CITY OF ALBUQUERQUE

January 24, 2025

**RE: Menaul & Vasser
2500 Phoenix Ave. NE
Grading & Drainage Plan
Engineer's Stamp Date: 01/03/2025
Hydrology File: H16D156**

MENAU AND VASSAR
 2500 PHOENIX AVE NE, ALBUQUERQUE,
 NM, 87107
GRADING AND DRAINAGE PLAN

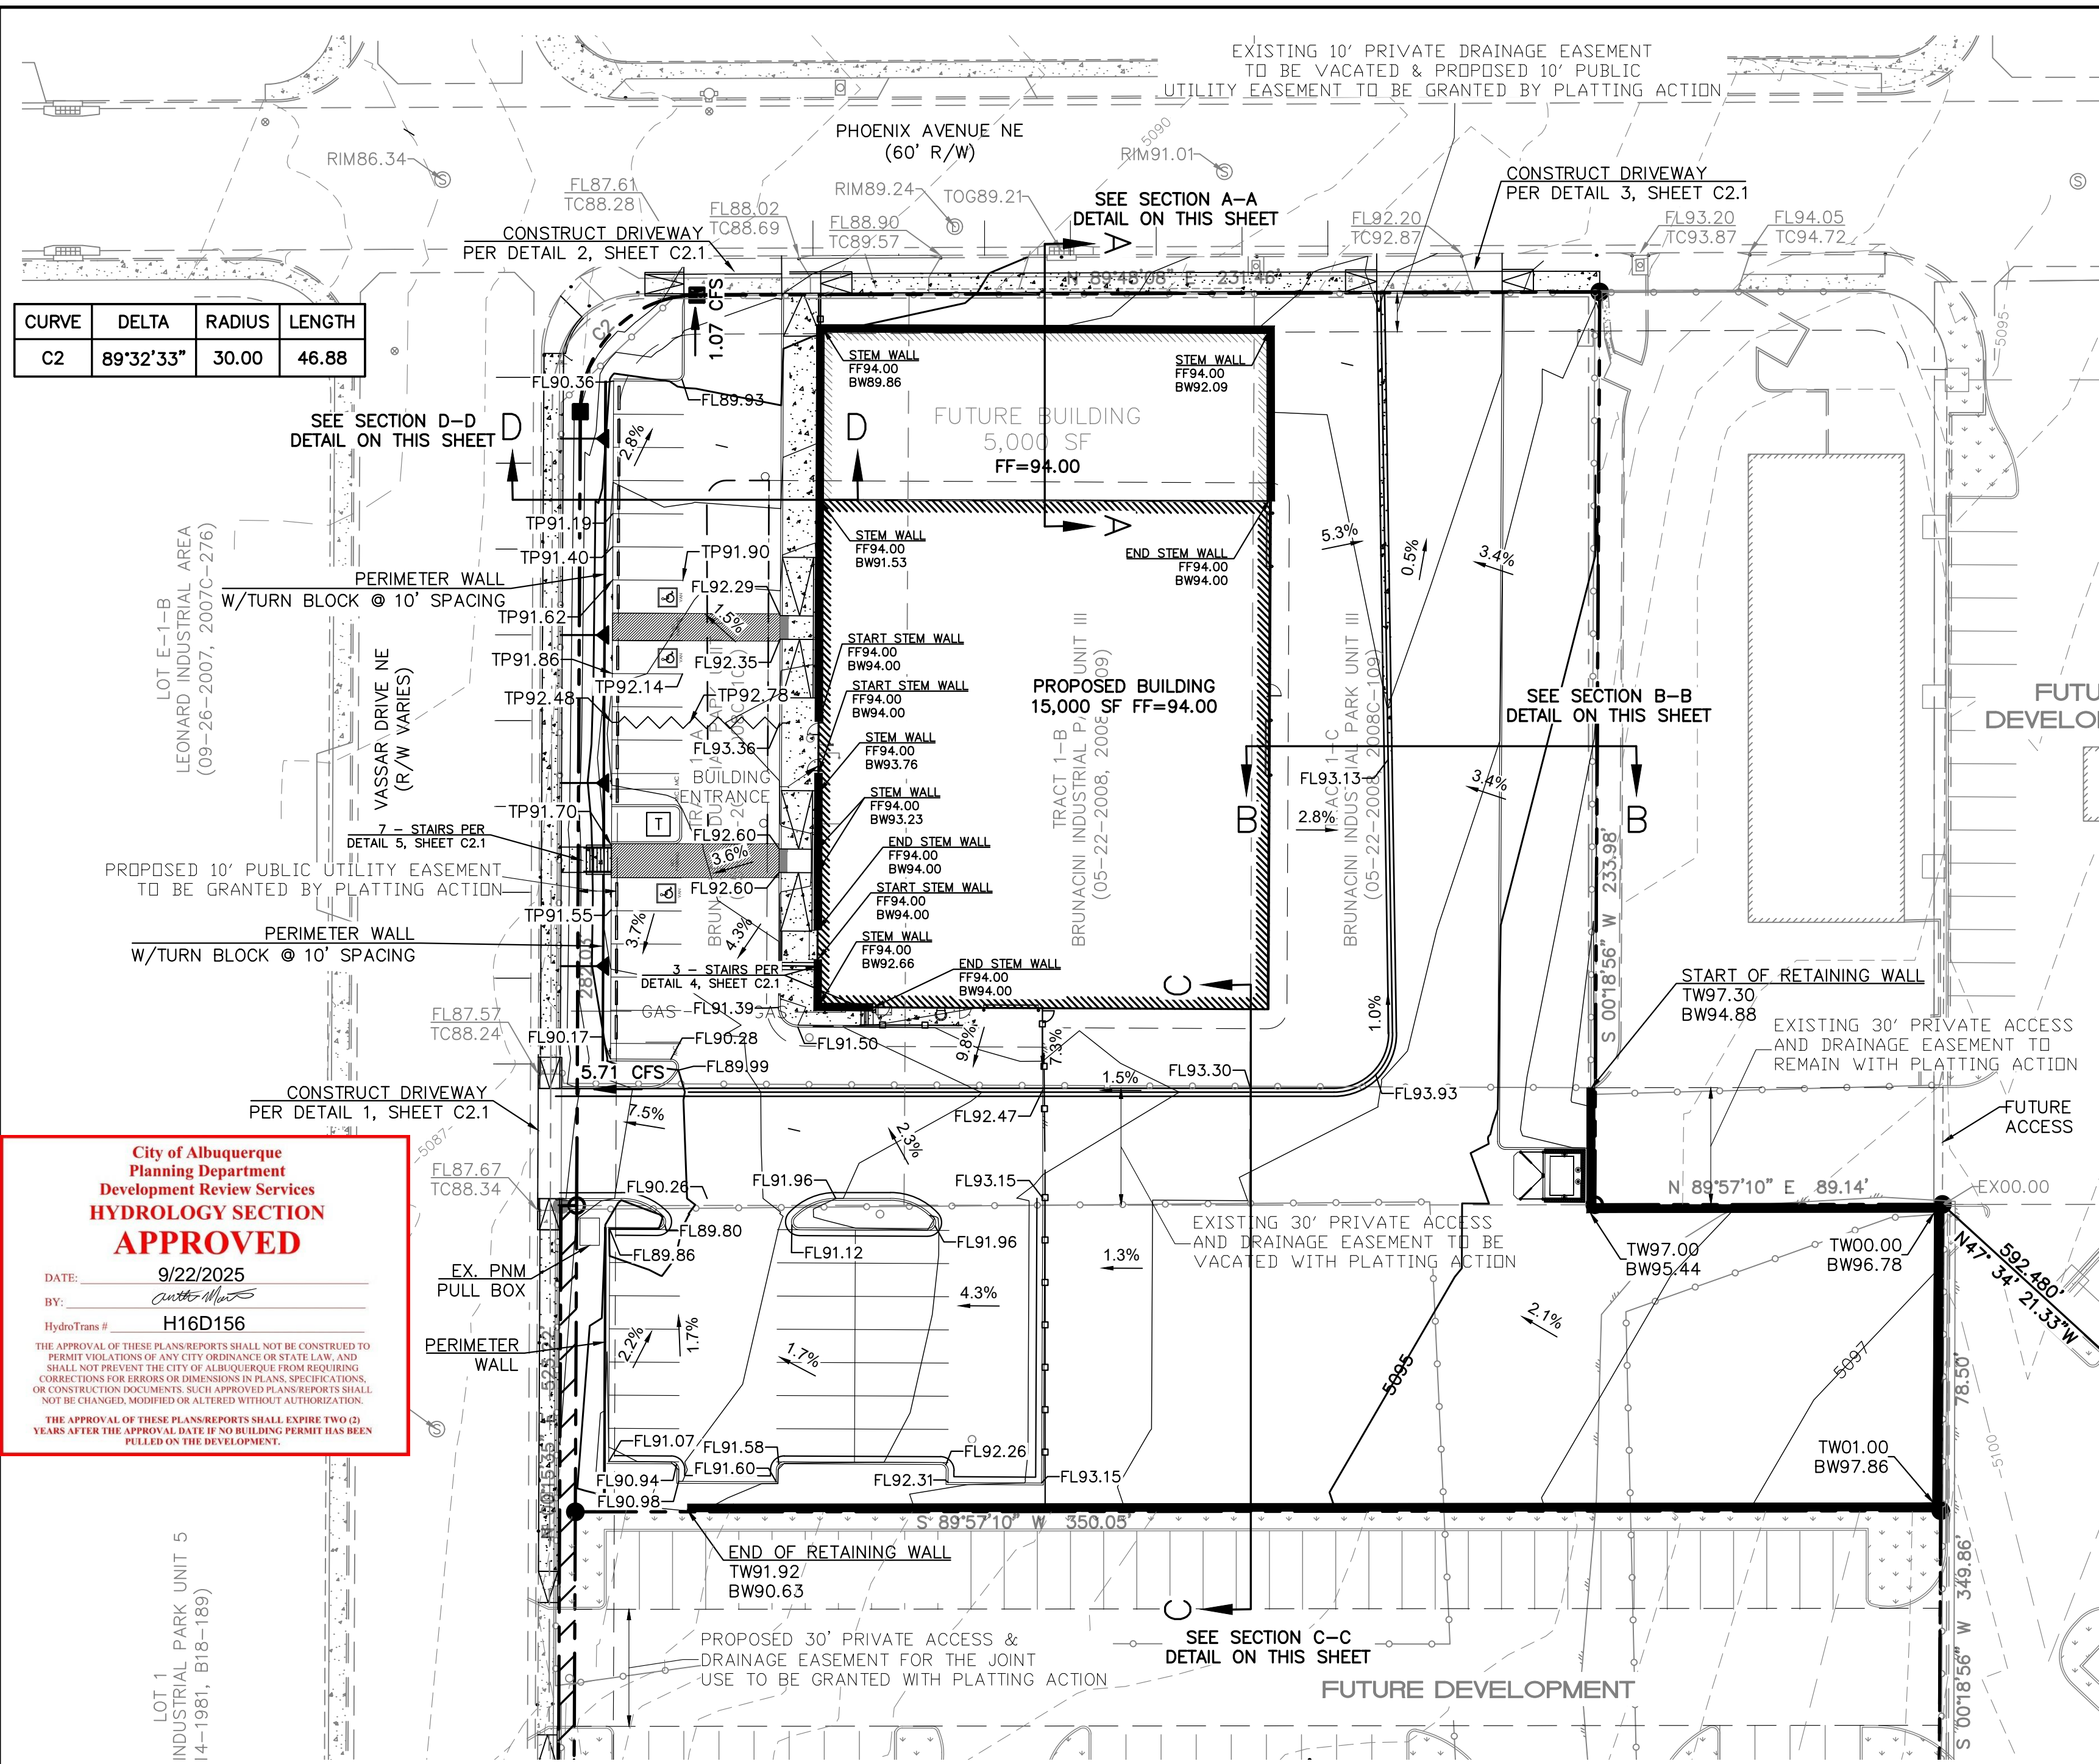
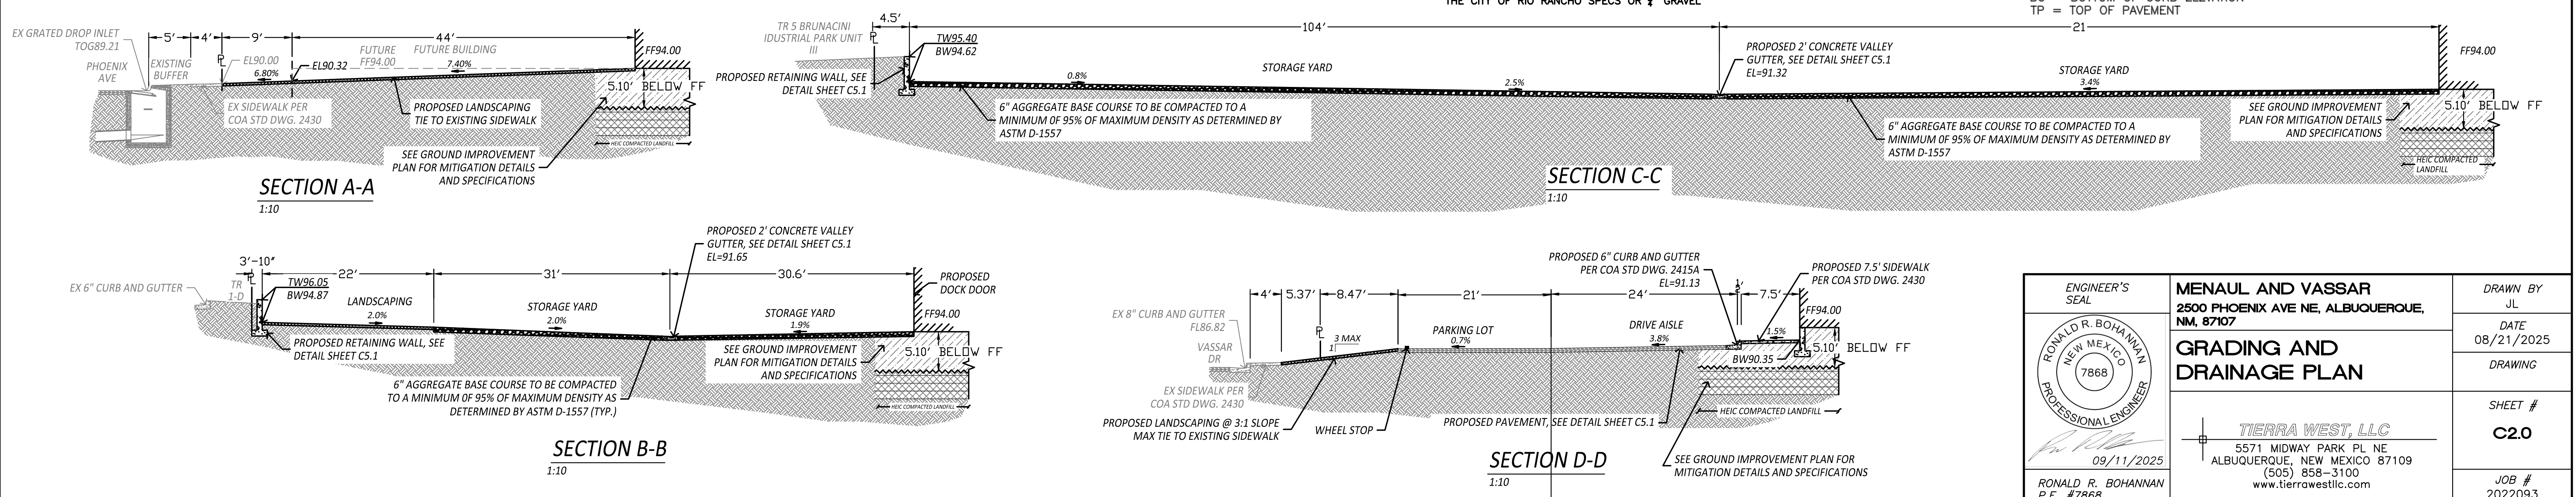
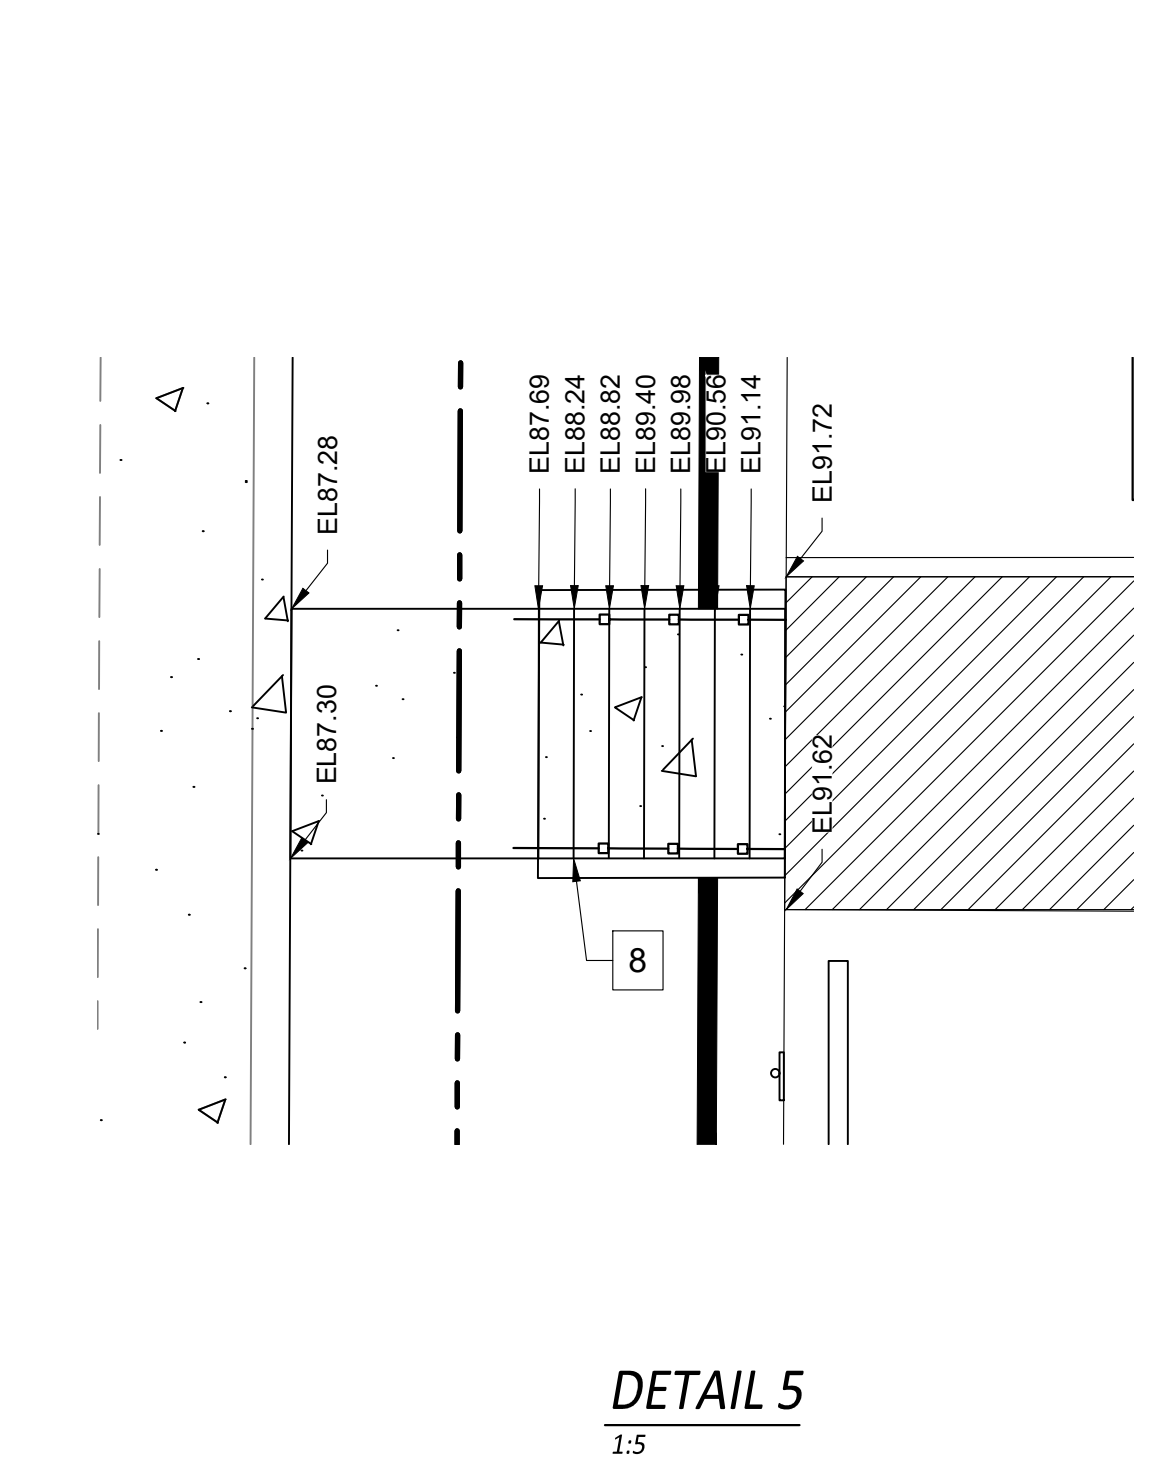
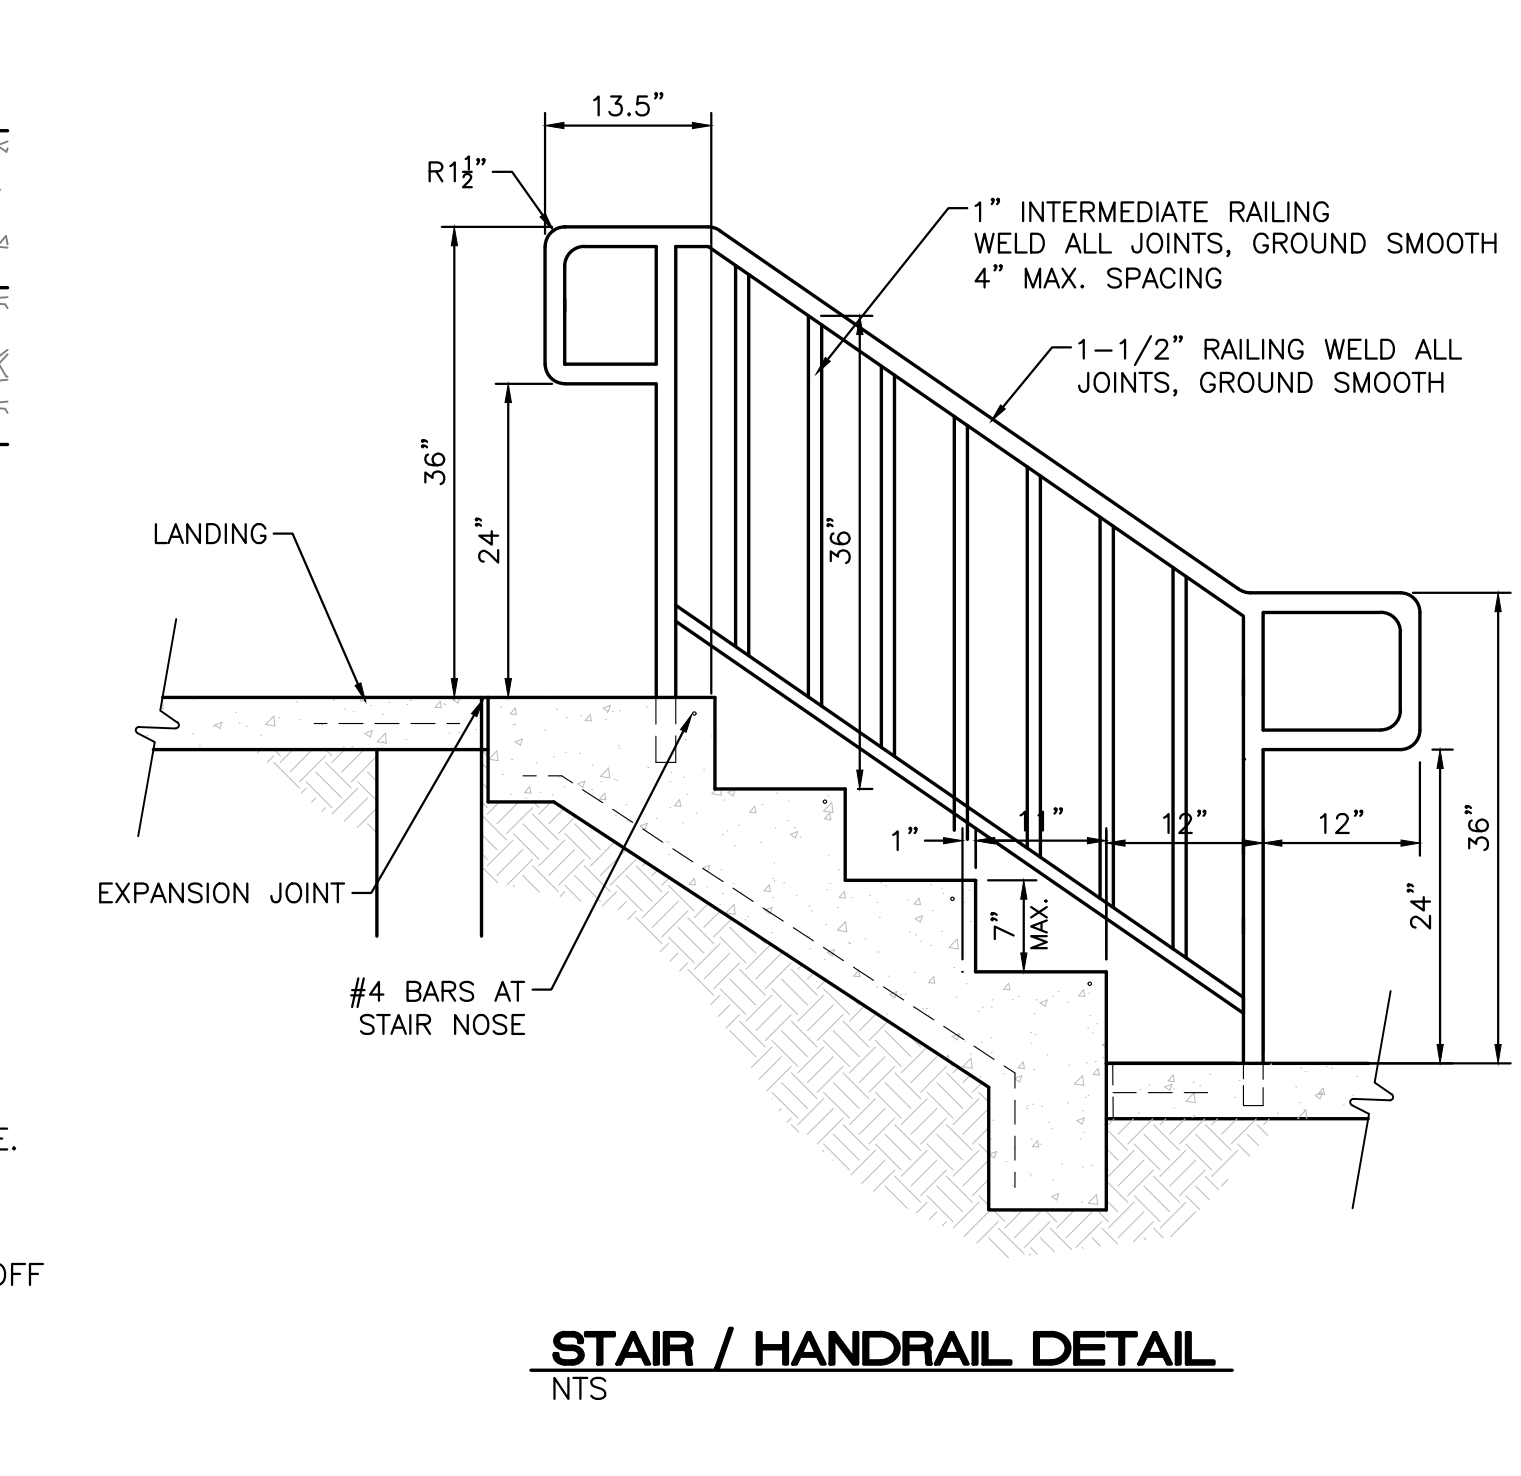
1. Sheet C2.0: Review and revise Section A-A to include the existing the storm drain grated inlet along Phoenix Ave.
2. Sheet C2.0: Review and revise Section B-B to include the existing concrete curb along the westerly boundary of 2600 Phoenix Ave. SE.

3. Sheet C2.0: Review and revise Section B-B to include the proposed pavement surface shown at the easterly side of said Section B-B on the plan in lieu of the proposed landscaping surfacing shown in the Section.

4. Sheet C2.0: For stormwater drainage purposes, Sections B-B and C-C should be reviewed for surface material types. Collecting and discharging stormwater from gravel surfaces onto a concrete valley gutter are rarely successful, and asphaltic pavement should be considered for all stormwater runoff areas.

5. Sheet C2.0: For stormwater drainage purposes, Sections D-D should be reviewed and revised to show the proposed 2-foot valley gutter leading north toward Phoenix Ave. per the Proposed Condition for Basin P1 stormwater runoff.

6. Sheet C2.0: Review and revise all Legend and Plan information and depictions regarding Base Course and Gravel.
7. Sheet C2.0: From field observations, the existing 30' Private Access and Drainage Easement appears to have an existing asphalt surface continuous to the property/parcel to the east. For stormwater drainage purposes, consideration should be given to maintaining this type of surface treatment in lieu of the proposed gravel surface.

8. Sheet C2.0: From field observations, the existing 30' Private Access and Drainage Easement appears to be providing access to the property/parcel/business to the east of this project which would be adversely affected by the proposed retaining wall, both for vehicular access and stormwater conveyance.
